Planning Application Ref: A/161/21/DOC

Location: Broadlees, Dappers Lane, Angmering, BN16 4EN

Description of works: Approval of details reserved by condition imposed under A/114/18/PL relating to condition 10-retention of existing trees/bushes/hedges.

Figure 2 Default specification for protective barrier

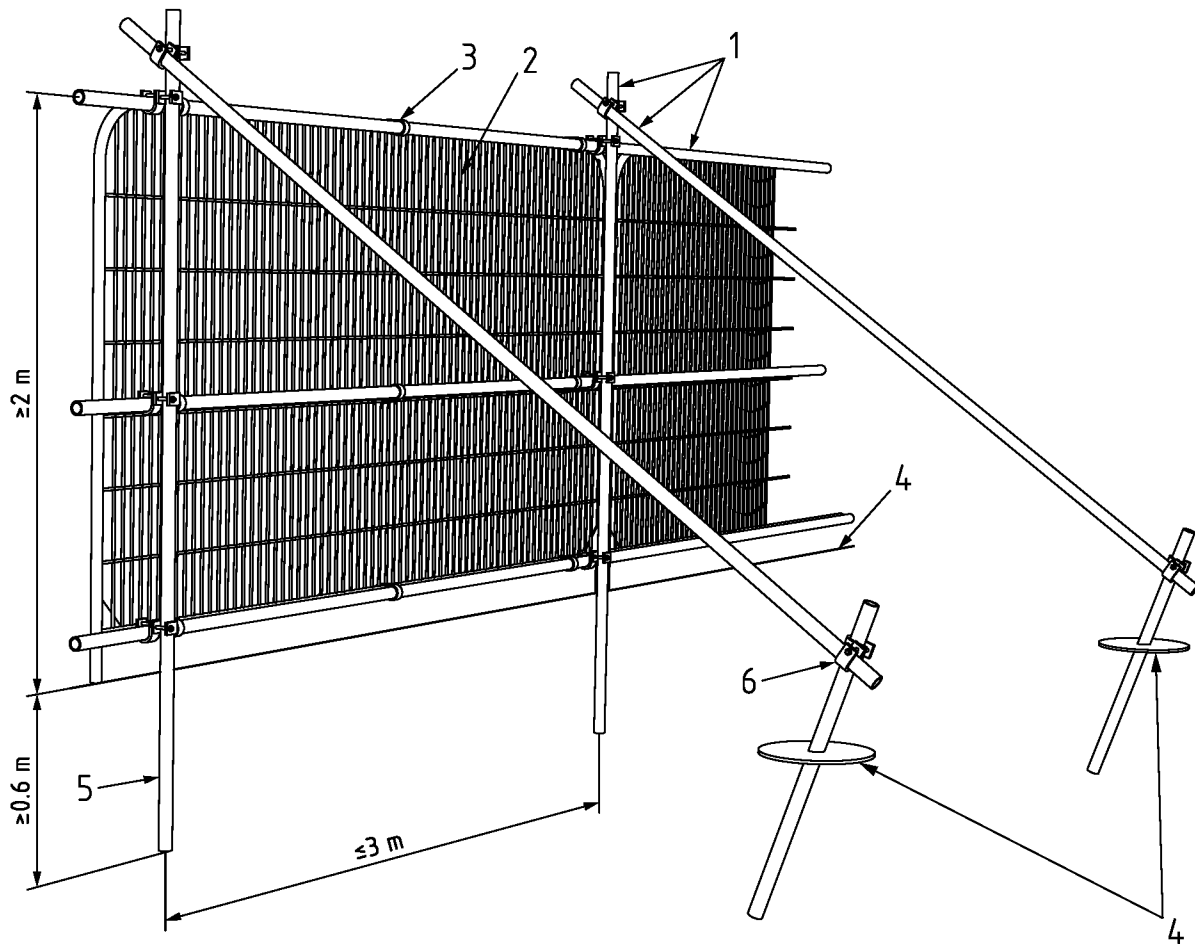
- The plan and supporting report **Tree Protection Proposals** from The Landscape Partnership, July 2021 promote BS5837:2012's default specification for fencing, to form an effective construction exclusion zone (CEZ) around retained trees.

Figure 3. – Scaffolding within the RPA

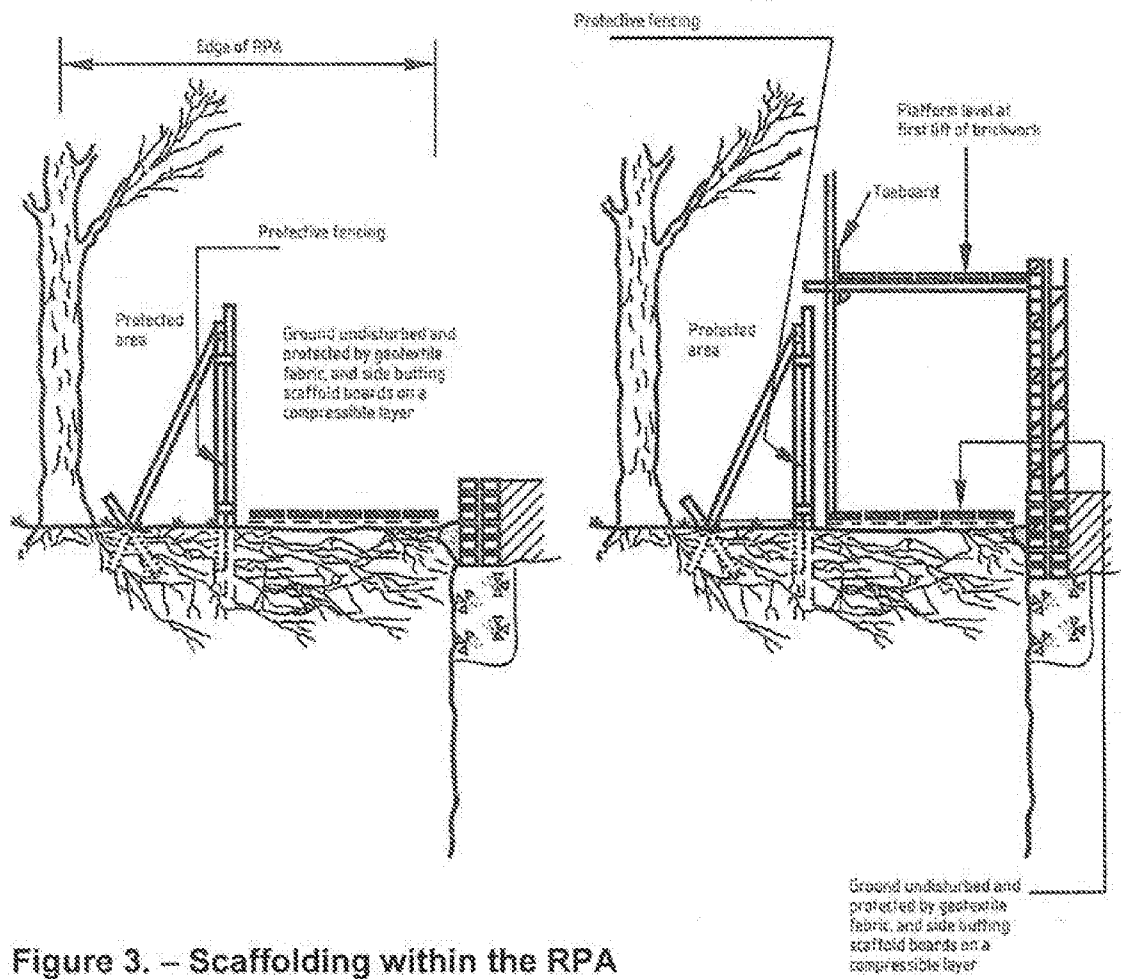
- It is probably not true to state (para. 3.3) that '*construction of the proposed development is wholly outside the tree protection areas of retained trees.*' That said, it is encouraging to see temporary ground protection promoted within root protection areas where construction related activity is planned (para. 5.2). There appears to have been an early attempt to implement that alongside T36-T38, although it is unlikely to be effective now and certainly vulnerable to further disruption if not removal during groundwork operations. All existing ground protection will need to be removed and replaced with fresh materials.
